Immingham Eastern Ro-Ro Terminal DCO: Submission of PAD Summary Statement

IMMINGHAM EASTERN RO-RO TERMINAL DEVELOPMENT CONSENT ORDER

PRINCIPAL AREAS OF DISAGREEMENT SUMMARY STATEMENT

DFDS SEAWAYS PLC

8.3.14 Figure 14.1 Sound monitoring locations

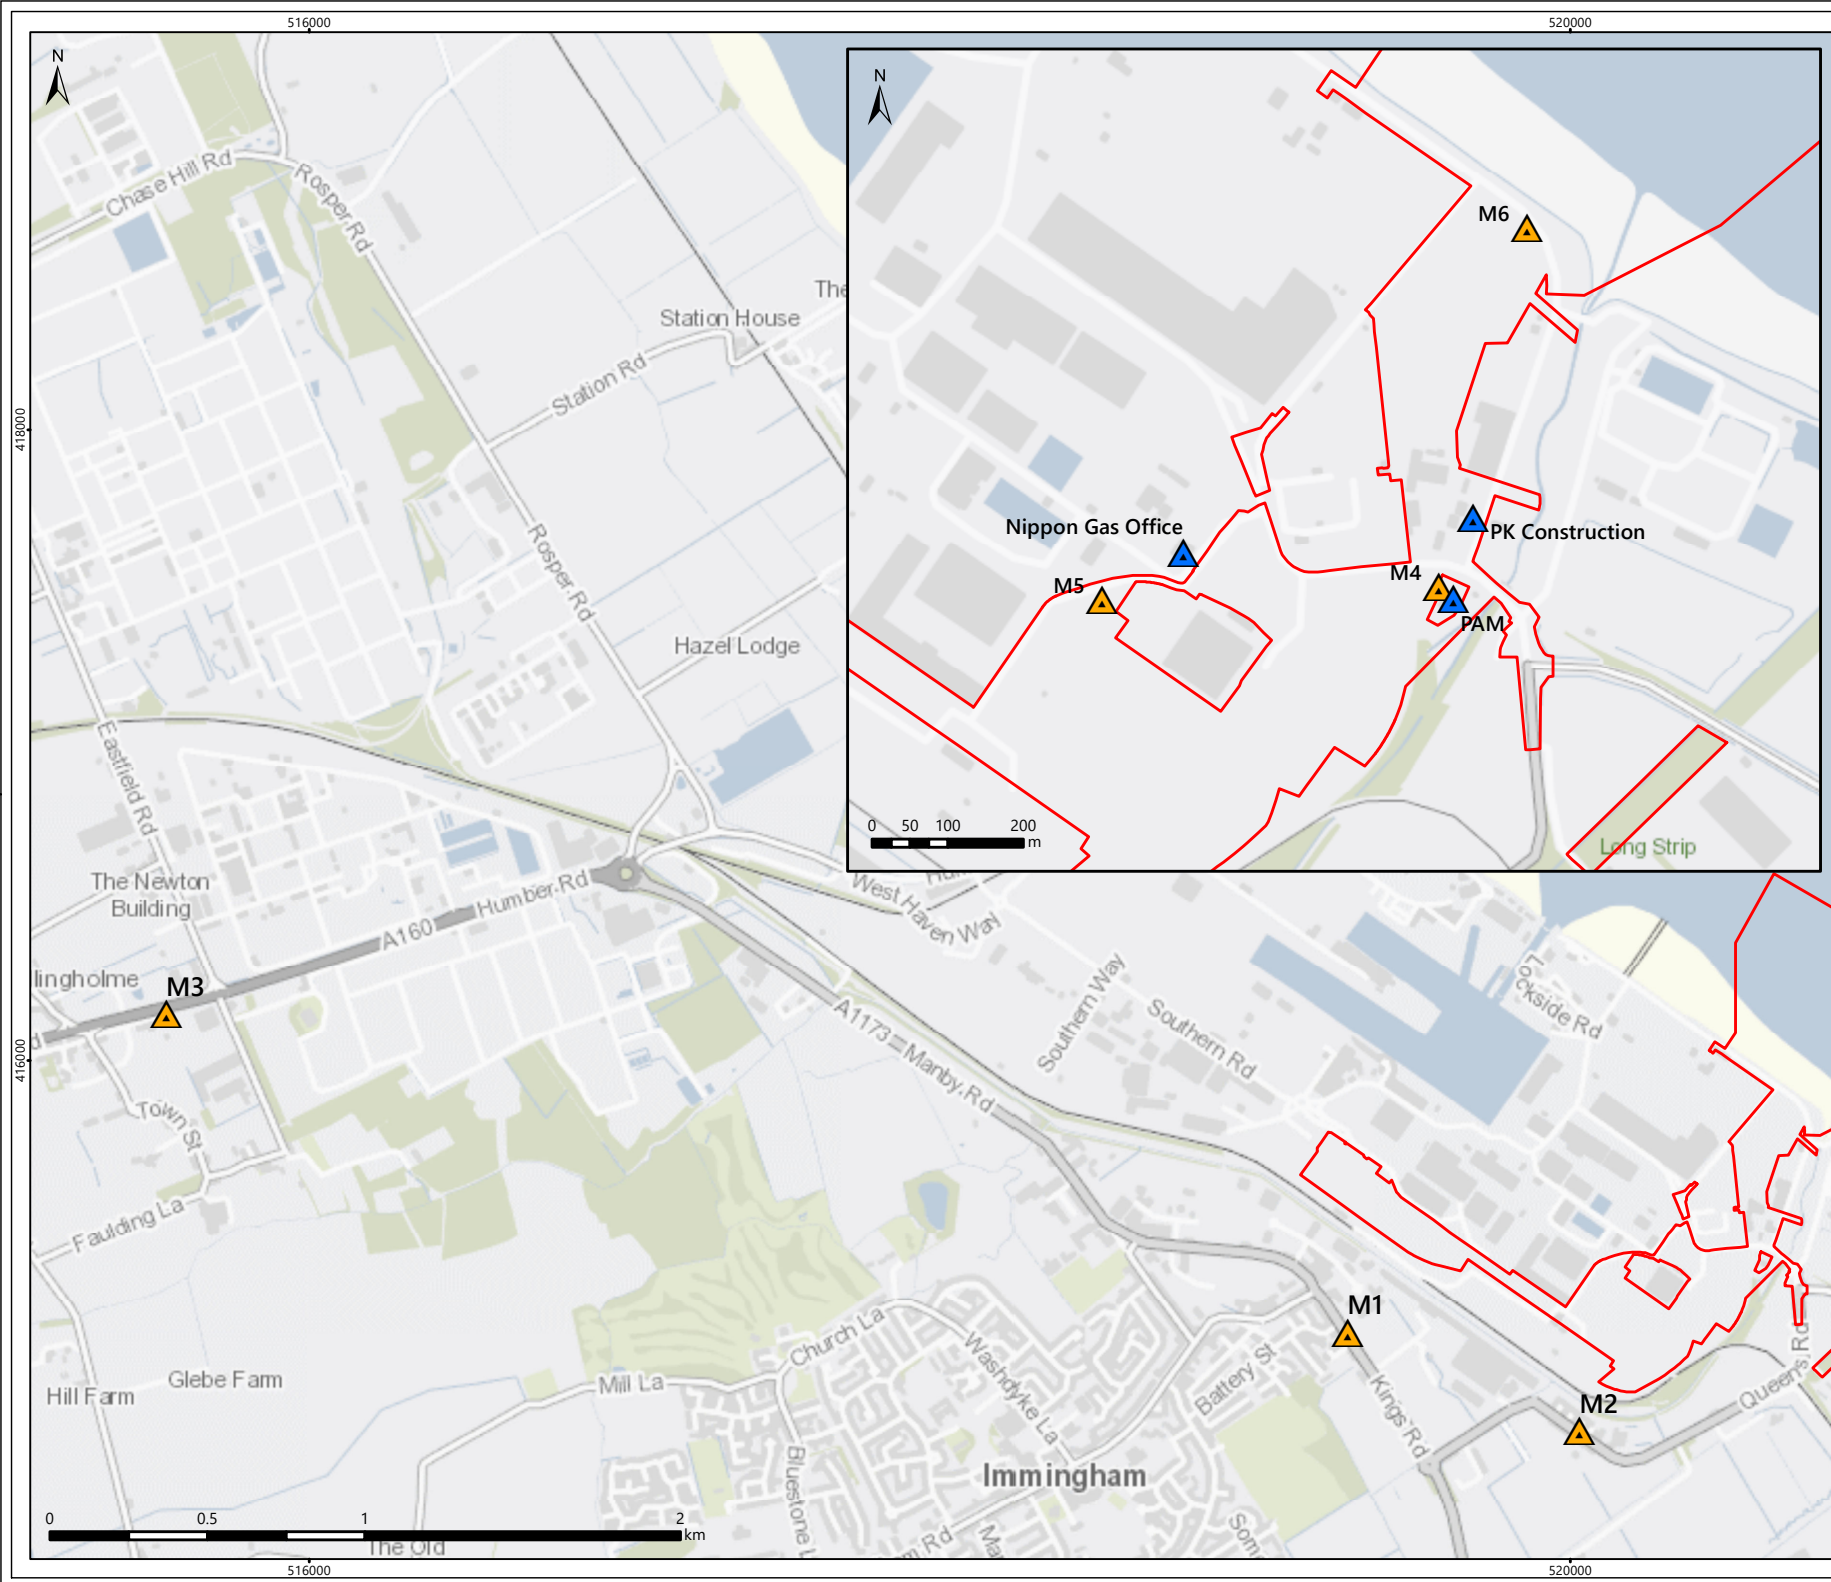
20.	Onshore issues: noise	<p>There is inadequate assessment of noise in Chapter 14 of the ES [APP-050]. Among DFDS' concerns:</p> <ul style="list-style-type: none"> - The assessment of construction noise does not account for existing background noise - The assessment assumes not all construction activities will occur at the same time but there is nothing to ensure that this is the case and no mitigation proposed if it does. 	Applicant to carry out adequate noise assessment	Medium
